From: Brenda Larsen
Sent: Tuesday, July 02, 2013 2:10 PM
To: Jeff Watson
Subject: RE: BL-13-00014 Ragland

Re: Ragland (BL-13-00014)

Brenda Larsen
Kittitas County Fire Marshal
509-962-7000

New Configuration

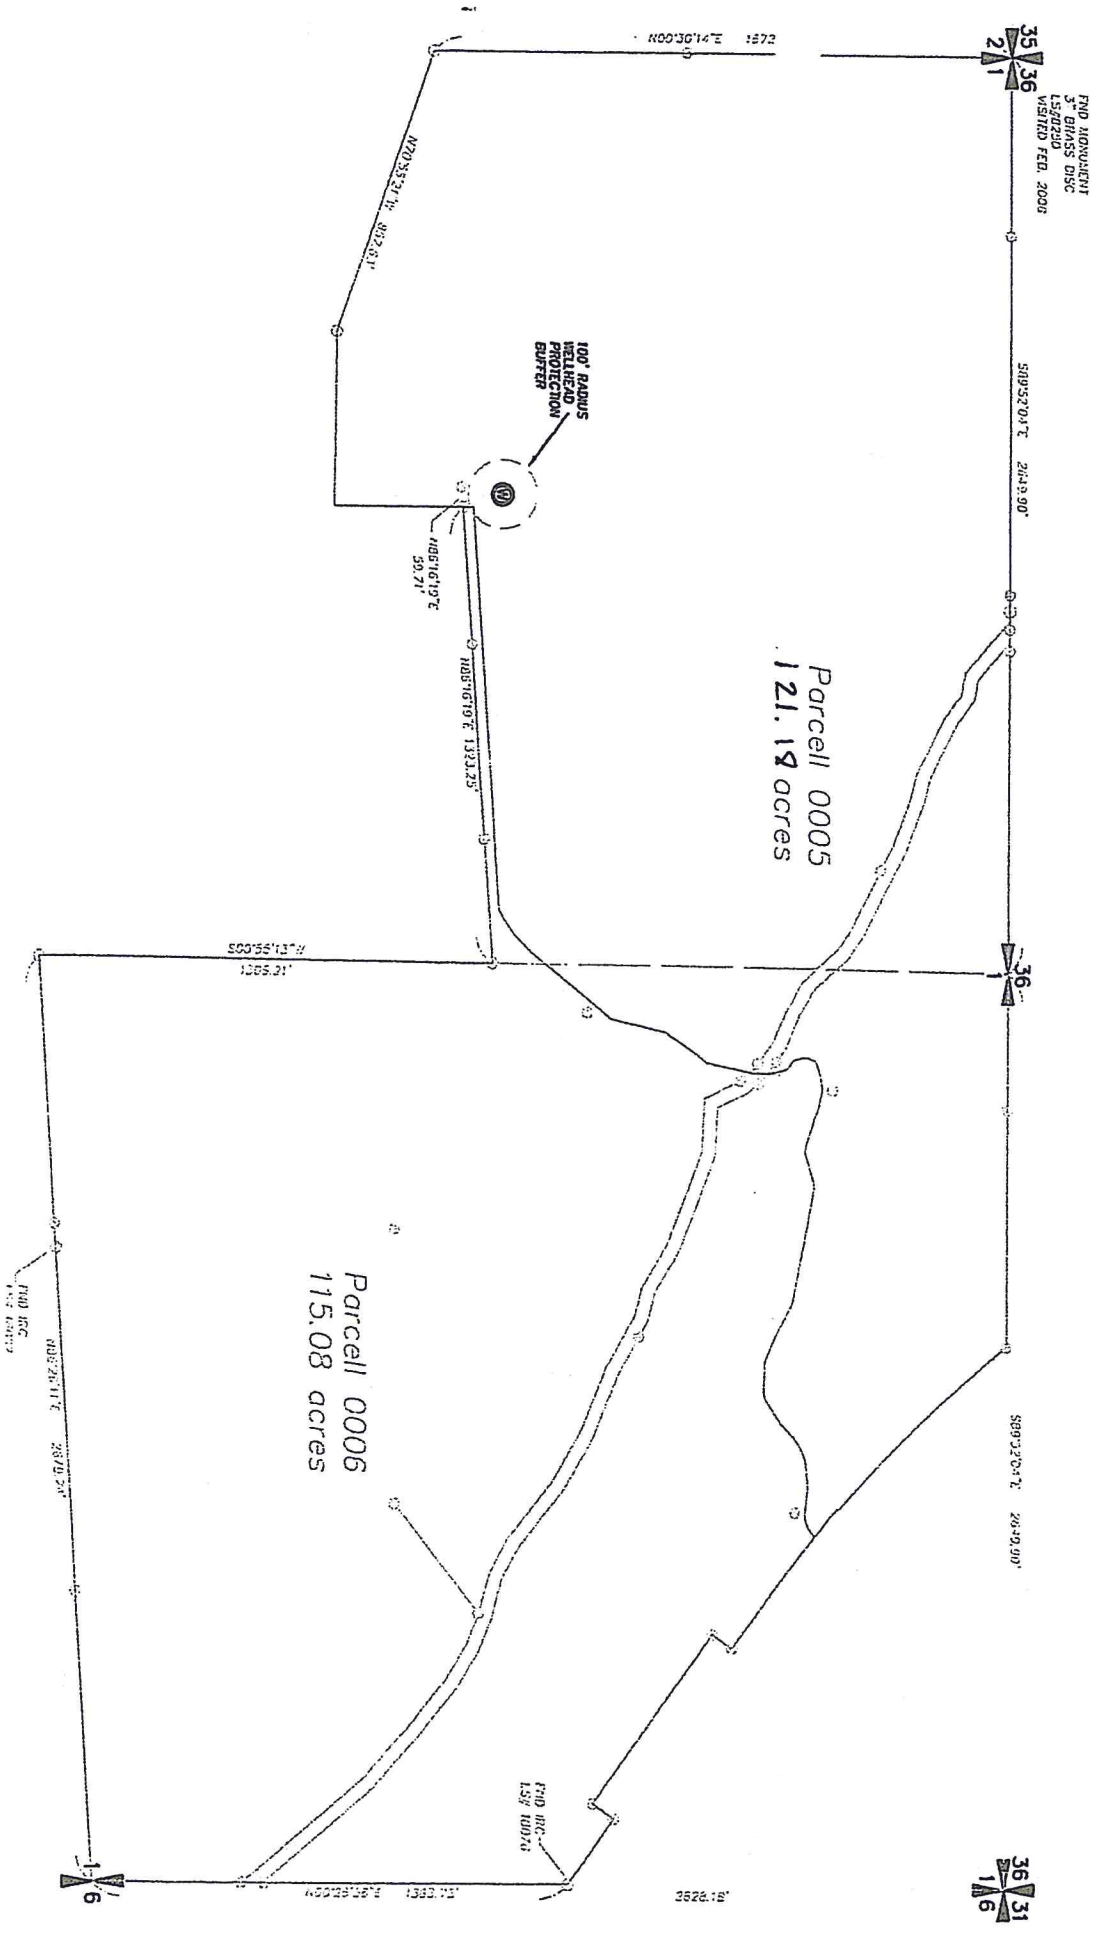
- Ensure that boundary line adjustments do not infringe upon existing structures, to include propane tanks, etc.
- Ensure adequate access for fire apparatus. Any driveways or access points created based off the new lot configurations shall comply with Kittitas County Code 20.02.030.
- All future development must comply with the International Fire Code.
